Subject **Re: 133 York Street/Harborview Flats**  
From Susan Kaplan <birmanmom@gmail.com>  
To Jeremy Benn <jeremy@joeflynnrealestate.com>  
Seth Page <sxp@earthlink.net>, Elliot Vrana <elliot.vrana@gmail.com>, Erin Foley <efoley19@aol.com>, Bruce Baker <brucewbaker.me@gmail.com>, Catherine Morrison <cmorrison@createagreement.com>, David Marsden <davidm@homesinmaine.com>, Jean Fraser <JF@portlandmaine.gov>, Erika Johnson <ejjohnson83@gmail.com>, Bill Mitchell <Bill@ghmagency.com>  
Cc  
Date 2013-09-24 18:00

RE: EMAIL FROM KAREN AND MARTY MCGEE  
133 YORK STREET

RE: McCORMICK PLACE CONDOMINIUM

SITE PLAN MAP 44/BLOCK A/LOTS 29 & 31

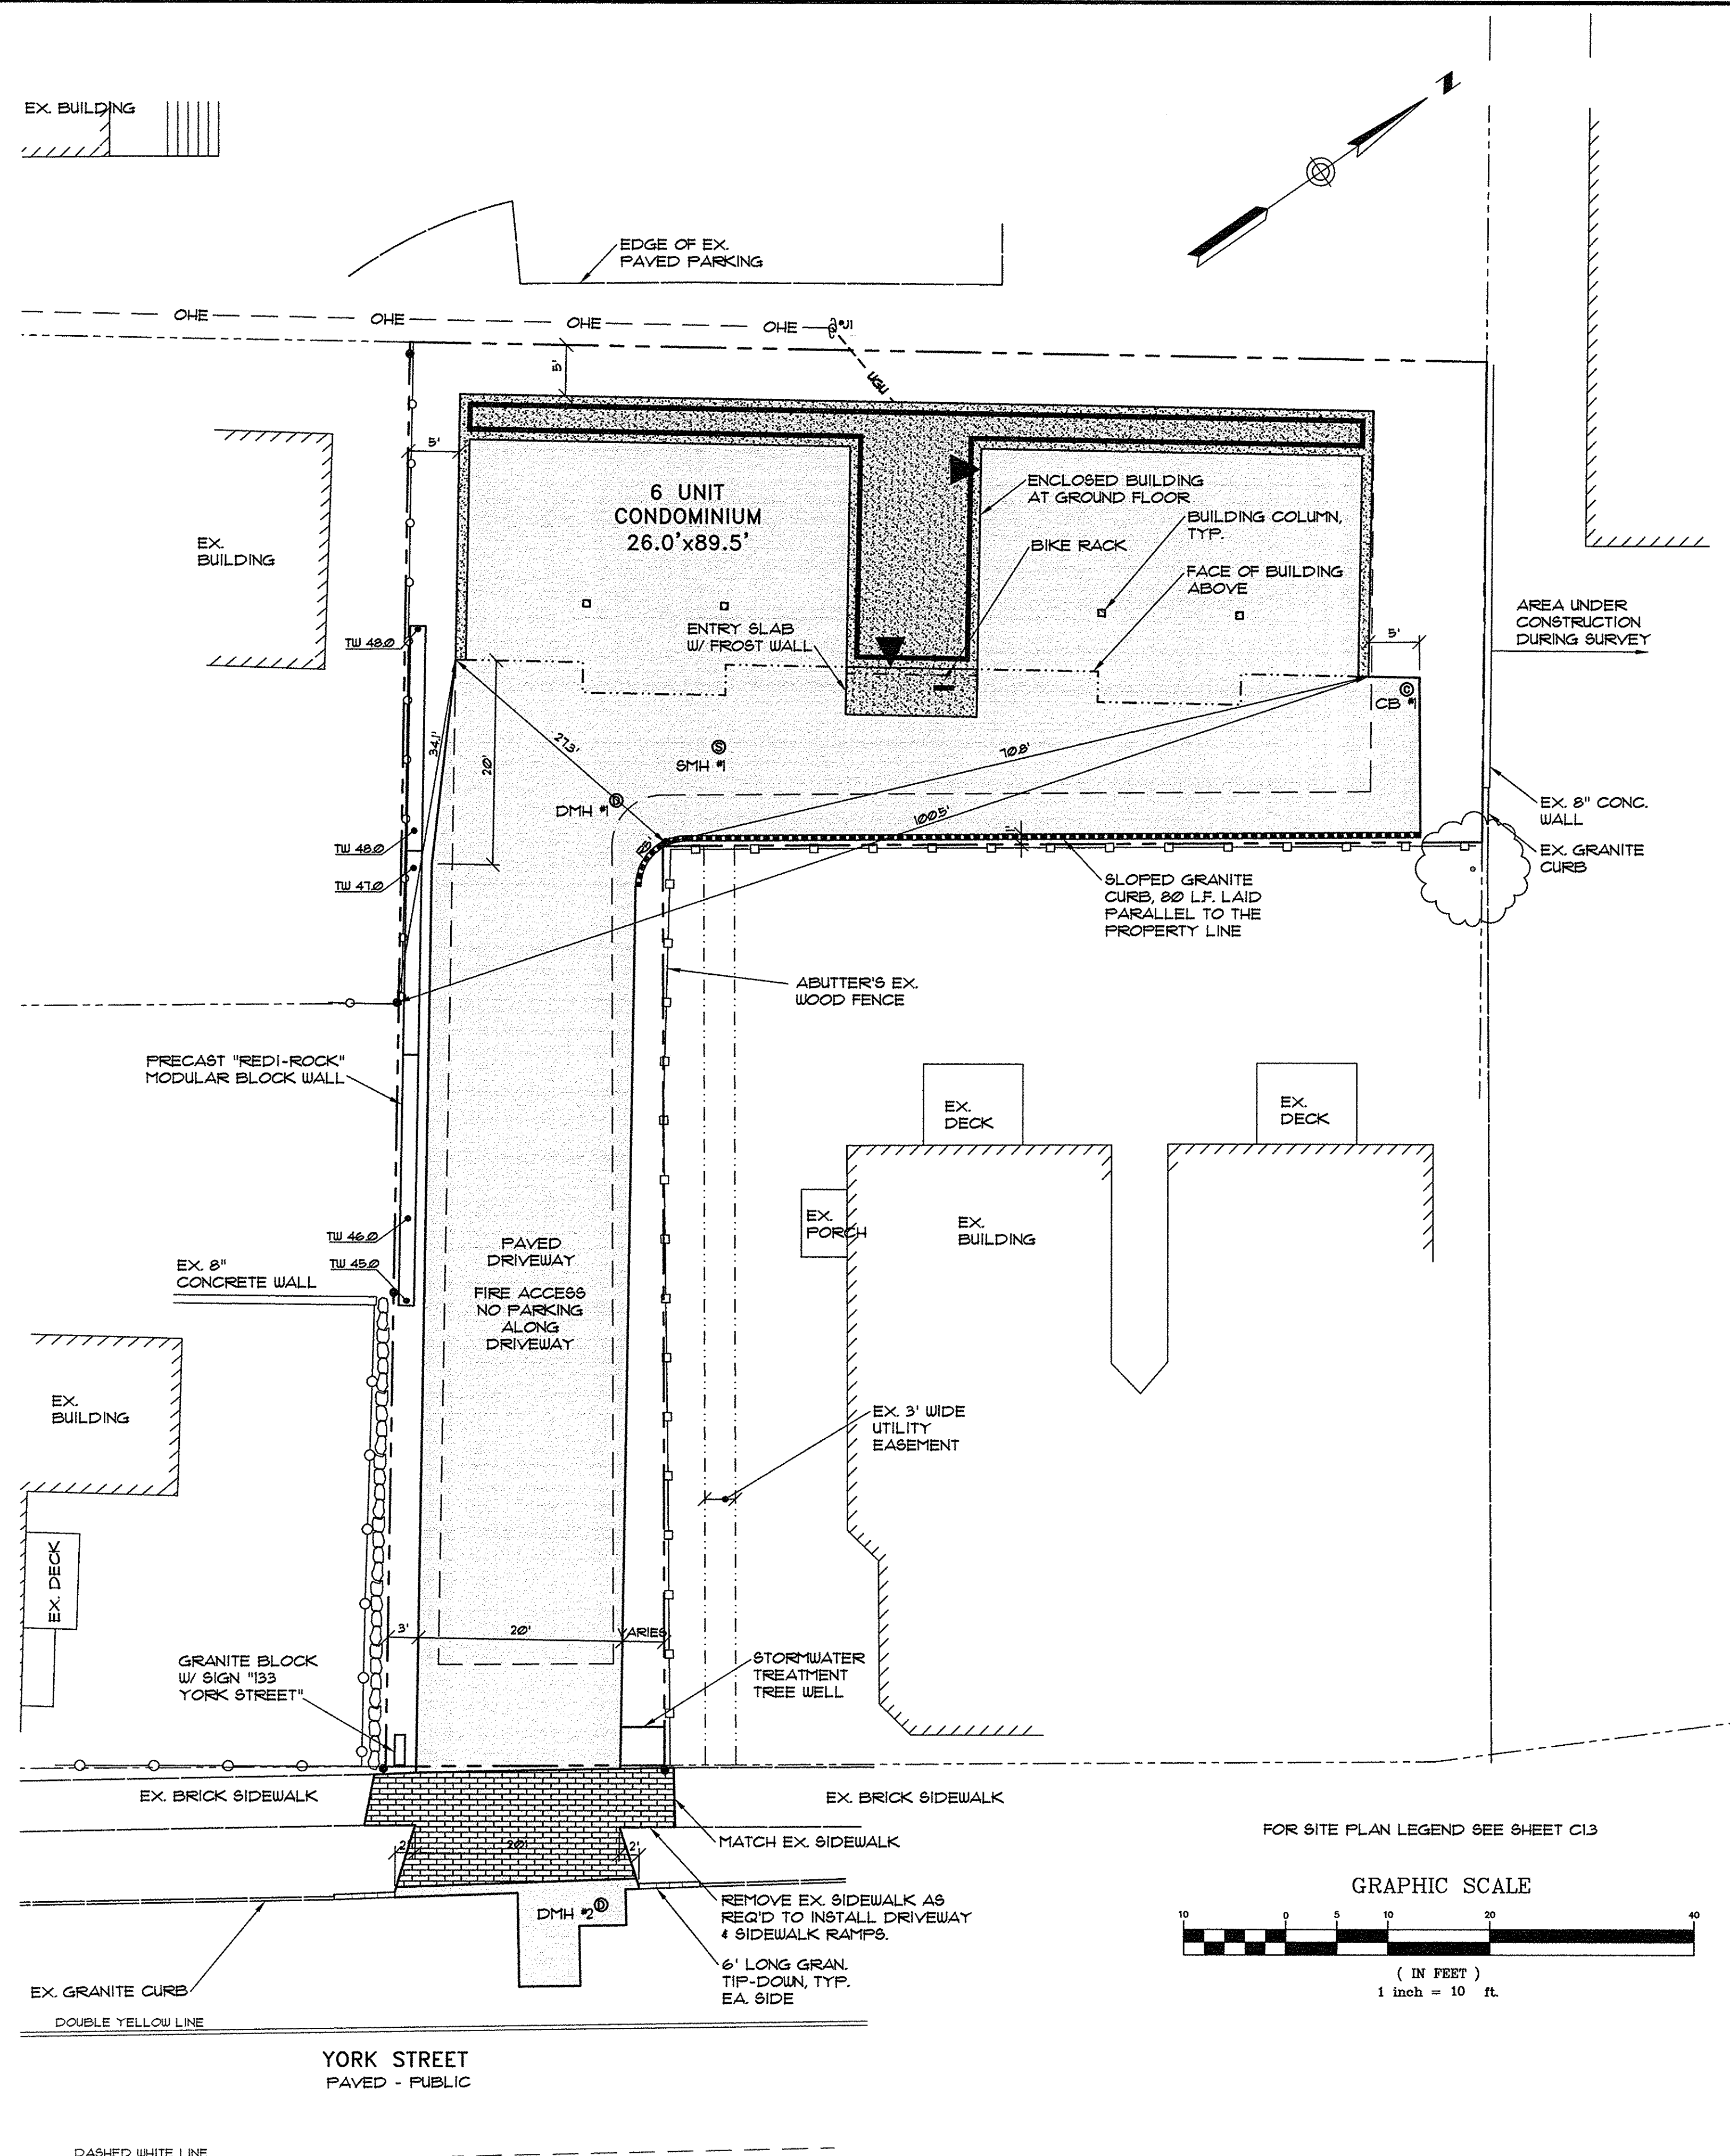
As the plan sits, the headlights from cars that are backed into your parking area will shine directly into the first floor condos (in blue) at the Flats. This unscreened area is noted with the red arrows above. The green wall and trees (as they are currently proposed) will not adequately address our concerns.

- 1) In your present design, is the green wall only planned for the section that is highlighted in yellow in the image below (the corner area)?
- 2) If YES, what provisions (beyond the trees you cited) have you made for affording the Flats screening and privacy from the parking area?

The suggestions in your email sound like you are moving in the right direction. When you say, "the corner of the fence in your backyard", can you give me a better sense of what area would / would not be screened by the green wall? As the plan sits, the headlights from cars that are backed into your parking area will shine directly into the first floor condos at the Flats. I would be very interested in additional details as to the placement and length of the green wall.

Do you have any plans for providing privacy or screening to the adjacent Townhomes building (the modern building next to your property)? There has been discussion about planting one or more small trees, but this will not afford the privacy that the present tree provides (which apparently cannot be saved with your current design). I will be interested in hearing your plans for that side of the property and will pass along your ideas to the Townhomes residents.

I see your concerns about the headlights as illustrated by the red arrows. I have asked the engineer to update the site plan to show a "green wall" to continue all the way across the fence. I will keep you updated on the façade.

- 1) The green wall goes beyond what you have highlighted, it is represented by the dashed line. It goes to about where the front door is located and further down the driveway.
- 2) The additional provision is in fact the two trees on the plan – this was suggested by the city arborist. We have added the trees and green wall to help with the privacy concerns.
- 3) The extra privacy for the town homes is provided with the additional 12 trees and shrubs as detailed on the plan.

I attached an updated site plan that illustrates the proposed trees and "green wall" addressing the planning board and abutters concerns. The plan identifies the location, species, and size of the plantings. I spoke with the architect this afternoon, he is working on the façade design. I will forward you the "re-worked" design as soon as it is available.

1. The current plan has additional landscaping across the property boundary as recommended by Jeff Tarling. If they would like to replace the trees in the corner on their property, we would be willing to pay for the trees.
2. The current parking is close to the boundary. We have provided a construction plan that addressed those concerns. If they are willing to provide a temporary construction easement we would be willing to pay for off site open air parking for the duration of the construction for 5 vehicles. We would also repair any damage that might occur as a result of construction. No access would be granted via the McCormick Place driveway.
3. We are planning to provide electrical and gas service from York Street. They use the existing pole to light the parking lot so the overhead service will remain as is.
